SUBMISSION- DATED 10 JULY 2010
MAITLAND TO MINIMBAH THIRD RAILWAY TRACK -HUNTER VALLEY

Submission for Job: #2924 Maitland to Minimbah Third Track - Project Application
https://majorprojects.onhlive.com/index.pl?action=view_job&id=2924

**Re: Maitland to Minimbah Third Track - Project Application
Submission from Hardie Taree Pty Ltd**

H8R DWG NUMBER 9 B	H8R-DWG-S2G-GEN-1085	Sheet No. 85 OF 89
	MAITLAND TO MINIMBAH - THIRD TRACK DETAIL PLAN CH222km580 TO CH222km920		Scale (A1): 1:500

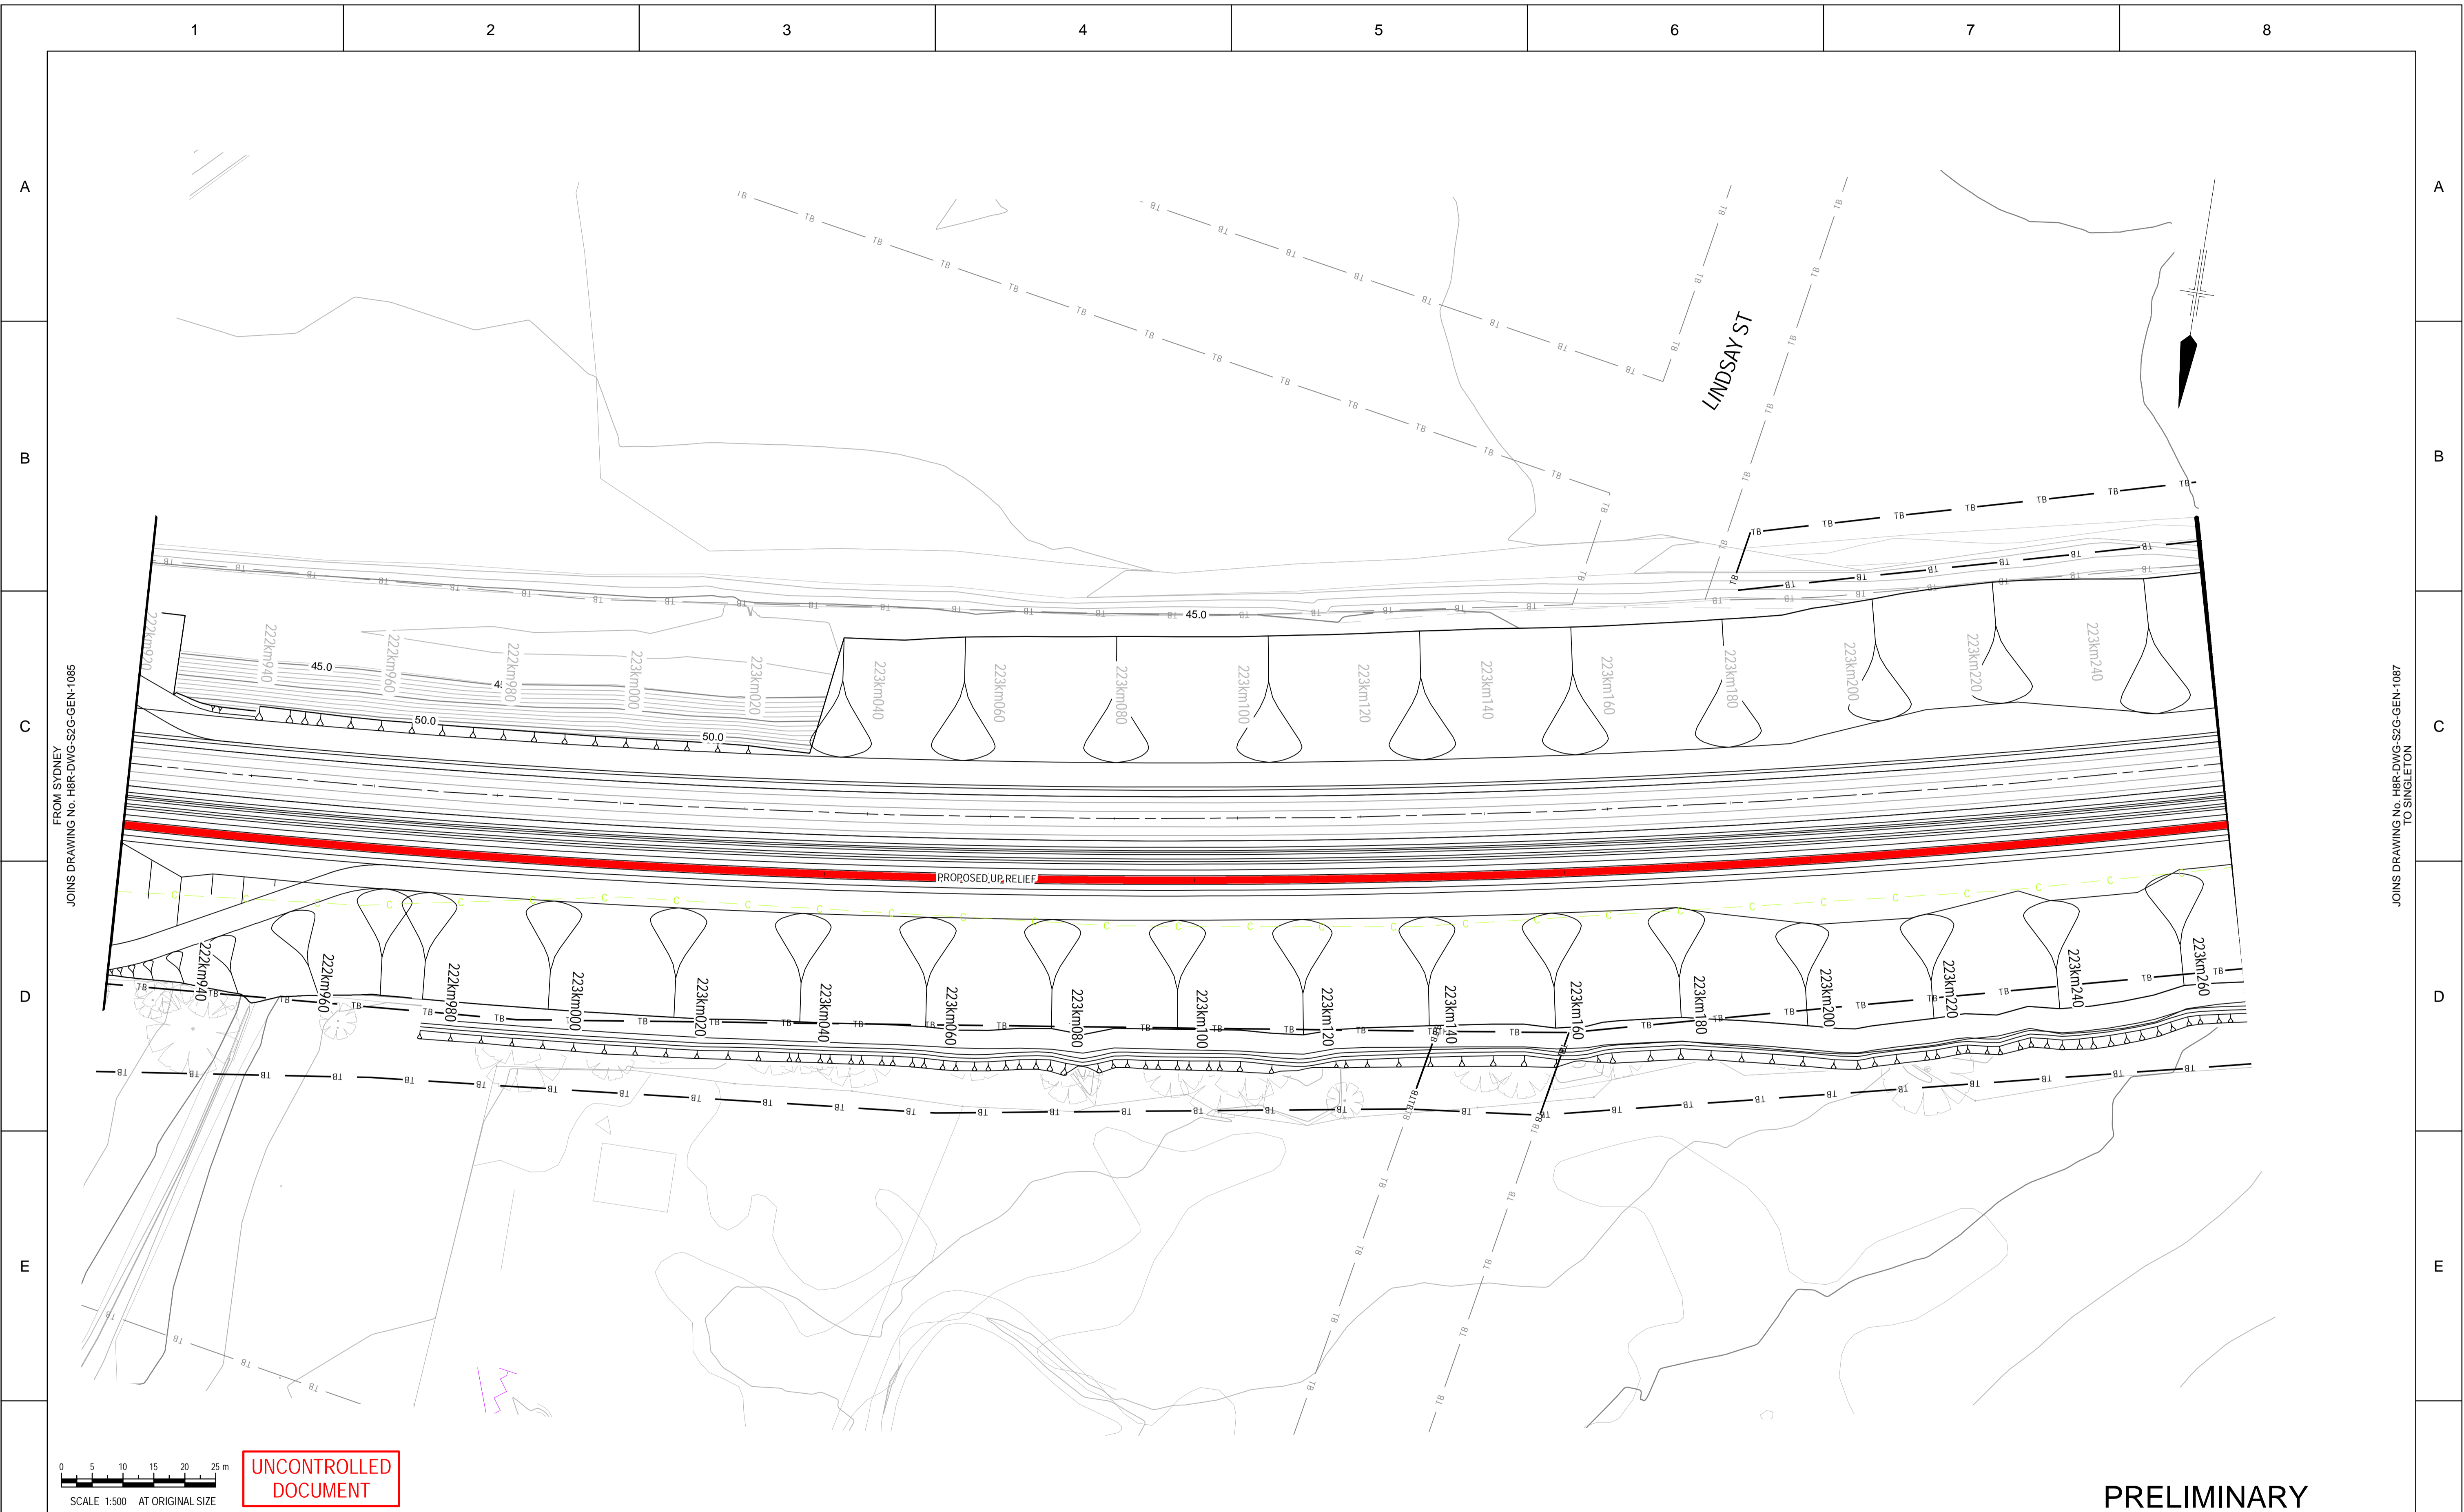
Hardie Taree Pty Ltd are the owners of land identified in the Project Application as potentially being affected by this application. Hardie Taree land holdings are lot 2 DP845380, Lot 3 DP845380 and lot 4 DP845380 located at the intersection of Hermitage Road and the New England Highway. The land coincides approximately between chainage 222.7km and 222.3km on the proposed Maitland to Minimbah third track plans.

An ancillary component of the Maitland to Minimbah third track project is the proposed road fly over of Hermitage Road to remove the at grade current rail crossing. Whilst not being approved as a direct part of this Part 3A application it is a critical component to the project.

Our concern is that the fly over being designed gives no consideration to our approved development layout. The proposed fly over provides an access road which is supposedly for our site, but the access road does not coincide with our development approved layout. We have further concerns that Hermitage Road is an existing approved RTA B-Double route however no consideration has been given when designing the access road to allow B-double trucks to enter and exit onto the proposed fly over road.

Summary – our concern is that no consideration has been given to our approved development site in the design of the fly over and access roads which are a critical ancillary part the Maitland to Minimbah third track project. What actions are the proponent of the Maitland to Minimbah third track proposing to undertake to ensure due consideration is given to an approved development site which has the potential to be suffer financial loss if no satisfactory consideration is obtained?
